PLANNING CONSULTATION RESPONSE

| Application No | 2025/0947 |
| Proposal | Renewal of external lighting and installation of CCTV (Listed Building Consent). |
| Address | Northern College, Lowe Lane, Stainborough, Barnsley, S75 3ET |

IP CCTV SYSTEM

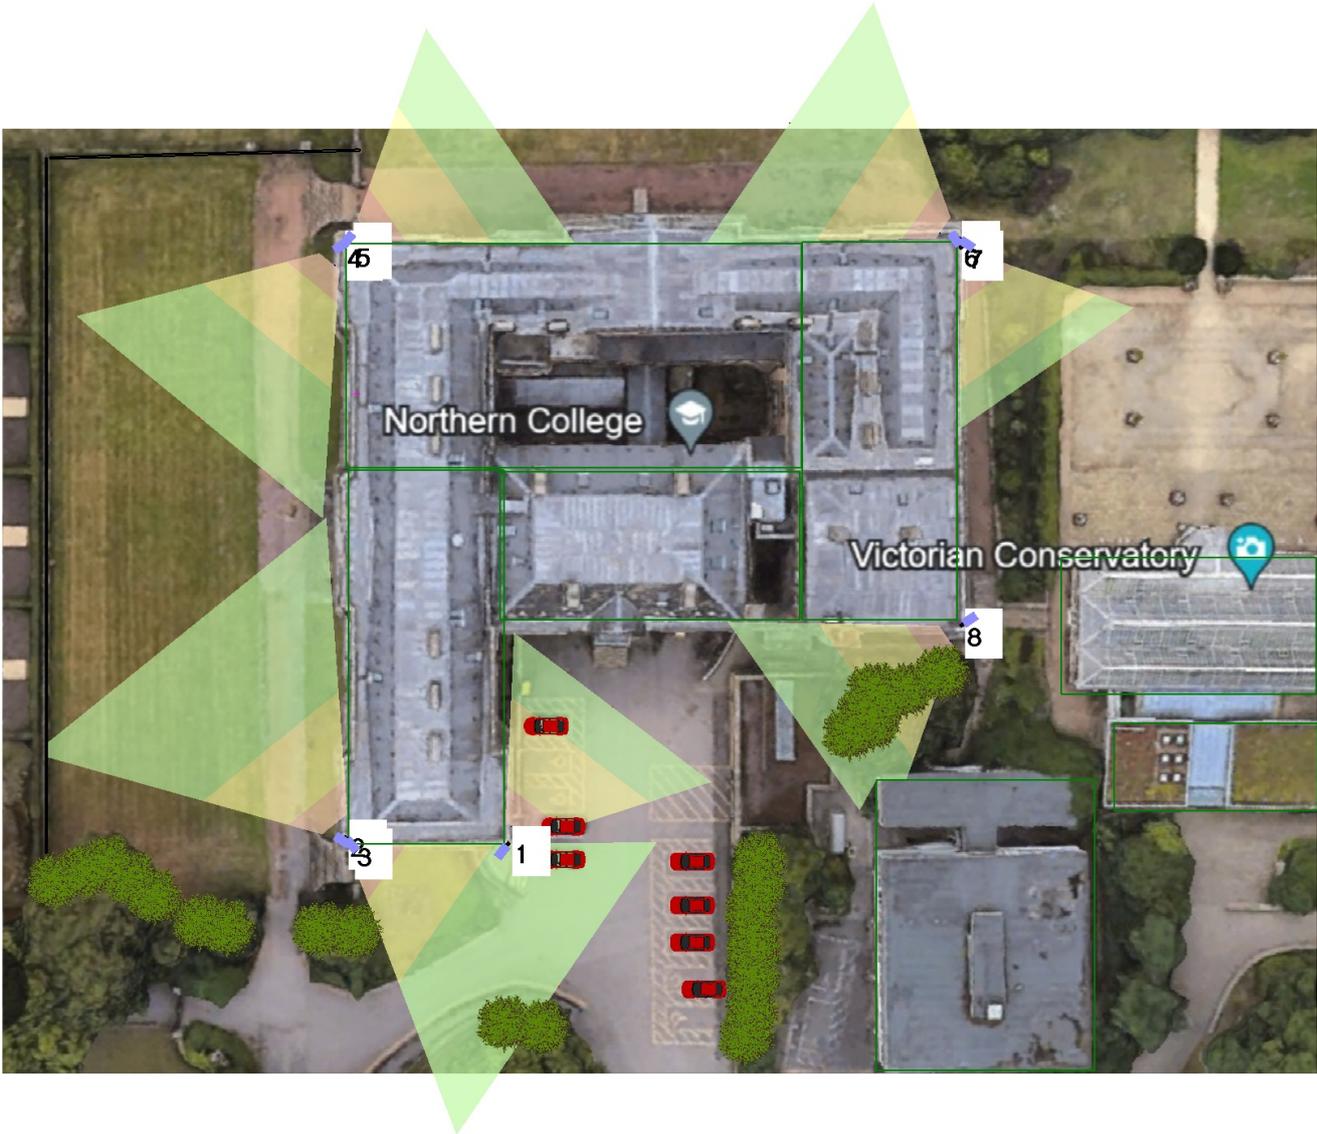
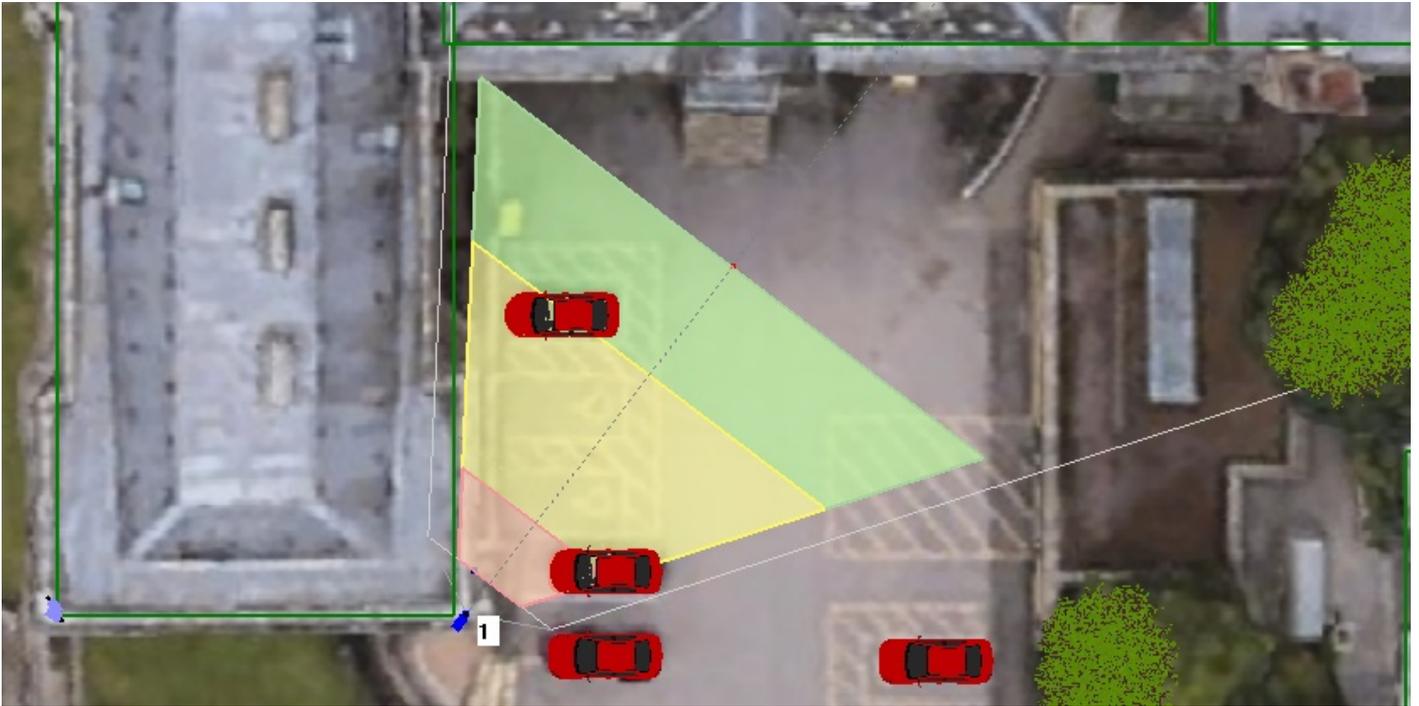
CCTV Assessment - The proposed CCTV installations are acceptable in principle, enhancing site safety and security. Units should be fixed within stone joints for reversibility and minimal harm, and wiring must avoid historic internal fabric such as decorative plaster.

- Replacement lighting units shall be fitted using existing fixtures and fittings.
- New lighting units shall be fitted within the joints of the stonework.
- The Cameras shall be black and fitted within the joints of the stonework.
